From: Paul Cann <Paul.Cann@arun.gov.uk>
Sent: 10 June 2022 10:39
To: Planning.Responses <Planning.Responses@arun.gov.uk>
Cc: Sarah Burrow <Sarah.Burrow@arun.gov.uk>
Subject: RE: Planning Consultation on: FG/65/22/DOC

Application No: FG/65/22/DOC
Registered: 14th April 2022
Site Address: Paddock House 44 Ferringham Lane Ferring BN12 5LU
Description of Works: Approval of details reserved by condition imposed under FG/115/1/PL relating to condition 7-surface water drainage.

At this stage we **would not recommend discharge of conditions** until the following comments are addressed.

Concrete Block Permeable Paving

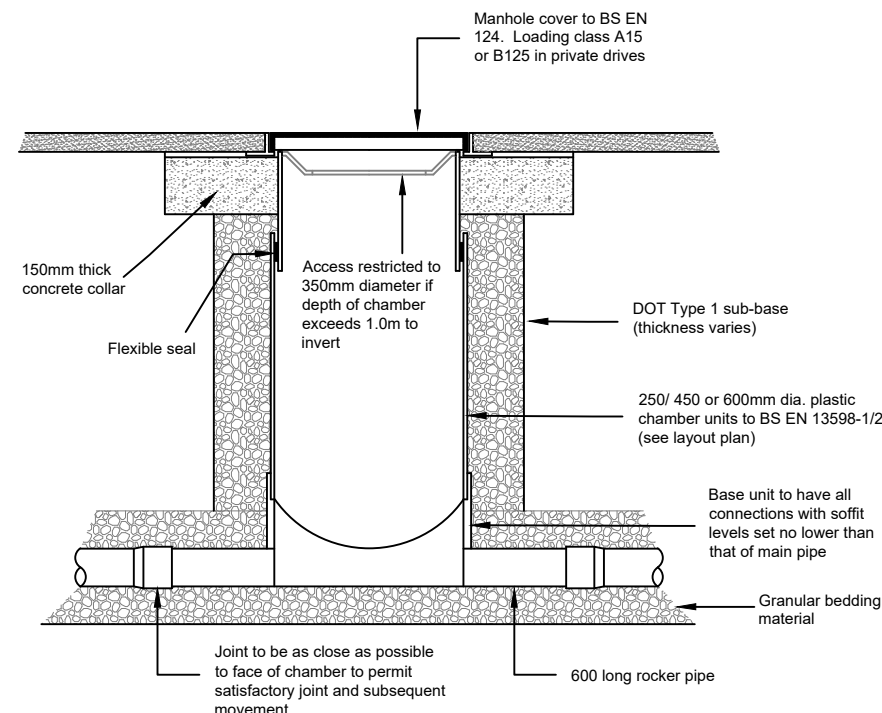
- A full detailed specification for the permeable surfacing system should be provided, this must include manufacturer specific details and the depth of the sub-base (an indicative design excluding structural calculations and without confirmed sub-base depths is not sufficient at the DOC stage).

TYPICAL PCC RING SOAKAWAY
IN PERMEABLE PAVEMENT AREAS

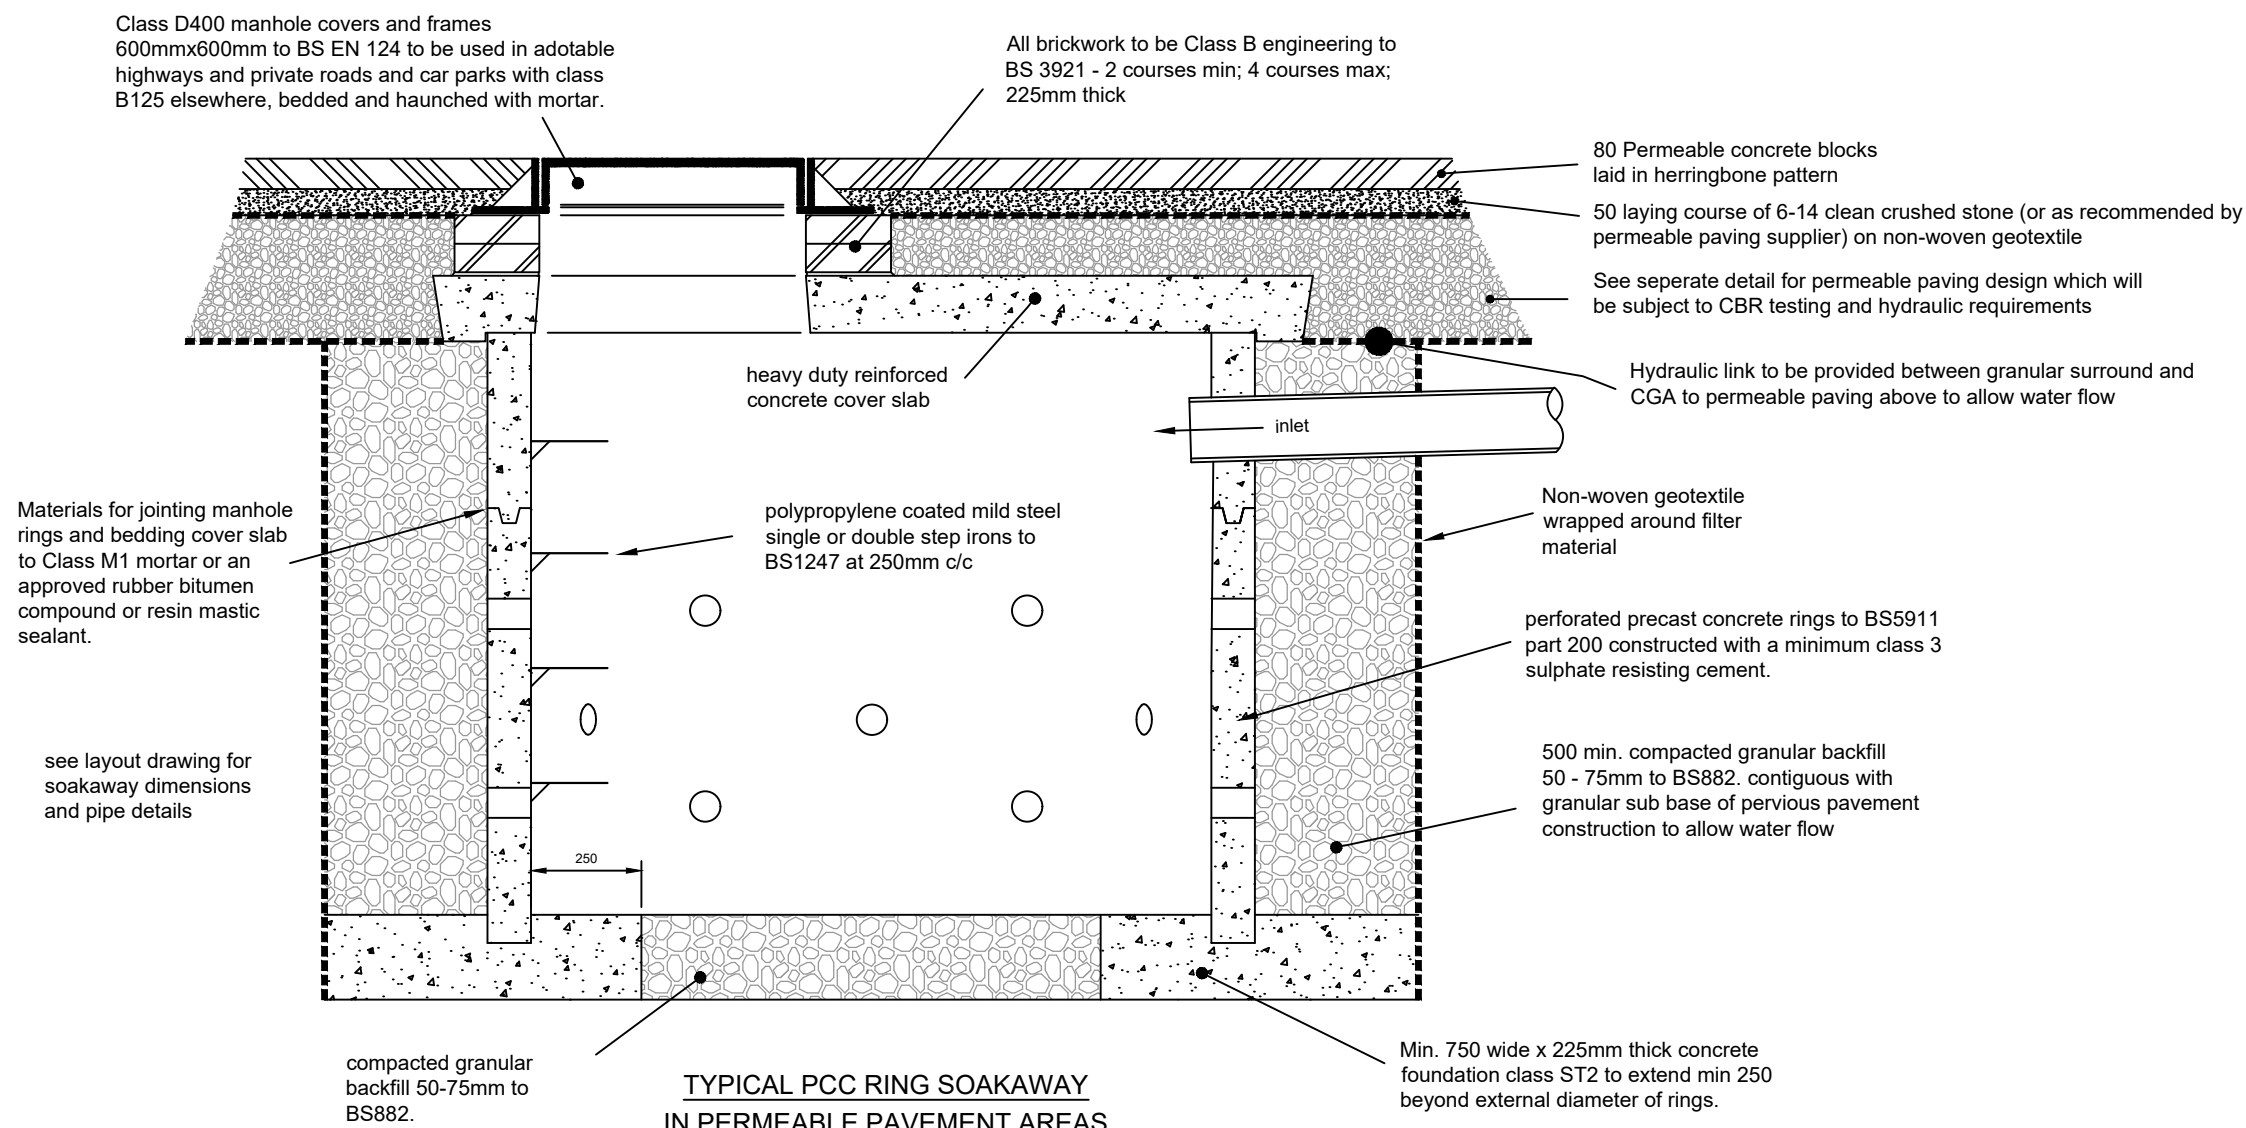
- This is to ensure that all testing is carried out in accordance with BRE365.
- 6. The Groundwater monitoring results show groundwater levels ~500mm below the surface. The base of the ring soakaways, and geocellular soakaway, are located below this level. The base of the permeable surfacing sub-base is not confirmed and may also be below this level. This will not be permitted as the base of any infiltration SuDS must be located above the groundwater table.

Typical Geocellular soakaway Unit
(for use in soft landscaped areas)
Scale 1:20

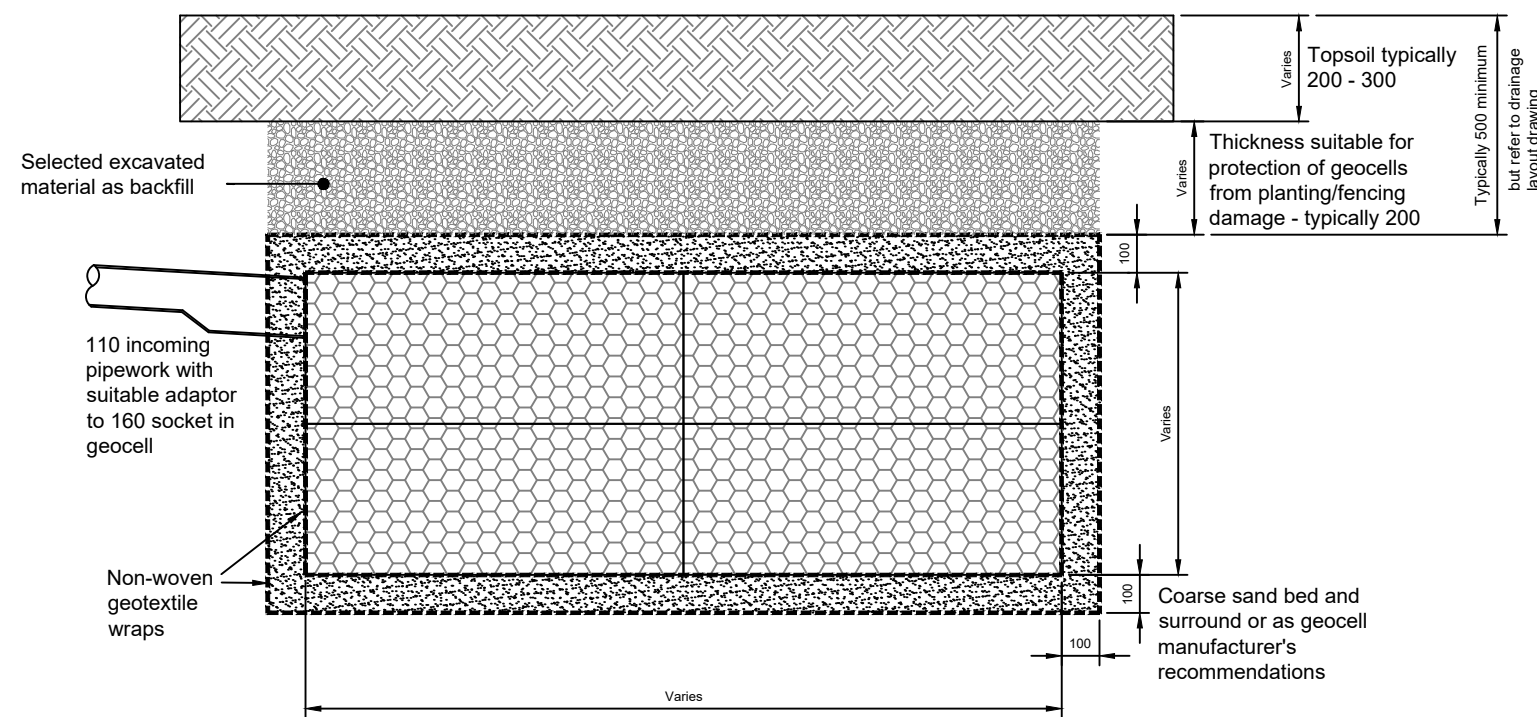
- A manufacturer specification for the geo-cellular soakaway crates.
 - The drainage layout plan should include a scale bar.
 - The location of the access point to facilitate the maintenance of the geo-cellular soakaway should be shown on the drawings.

- The cross section drawing of the geo-cellular soakaway should include a note confirming that the geotextile will be permeable.
2. The applicant should confirm that all SuDS are located outside of the root protection zones (RPZ) for the trees located within gardens of the adjacent properties.

- In particular, the applicant should confirm that the geo-cellular soakaway is located outside of the RPZ for the trees adjacent to little paddocks (road / lane).
